## **Kirklees Flood Management & Drainage (Lead Local Flood Authority) – Consultation**

**Consultation on Application Number: 2018/93201**

**Address: land at, former St Luke's Hospital, Blackmoorfoot Road, Crosland Moor, Huddersfield, HD4 5RQ**

**Proposal: Reserved matters application for residential development pursuant to outline permission 2016/91337**

SCALE AT: 1:500	DATE: 11.09.18	DRAWN: TS	CHECKED: --
PROJECT NO: 1835	DRAWING NO: 1835.100	REVISION: --

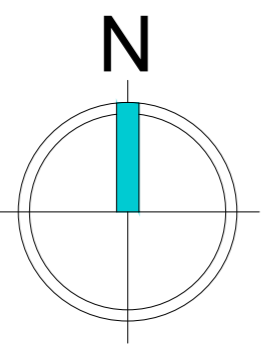
- **A more detailed drainage provision is required omitting the use of 1500mm tanks to ensure 'space has been made for water' given parameters set for road adoption. The submission to date is incomplete.**
- **A more detailed analysis of flood routing using both tank positioning and that of road layout is required at this stage before approving a layout.**
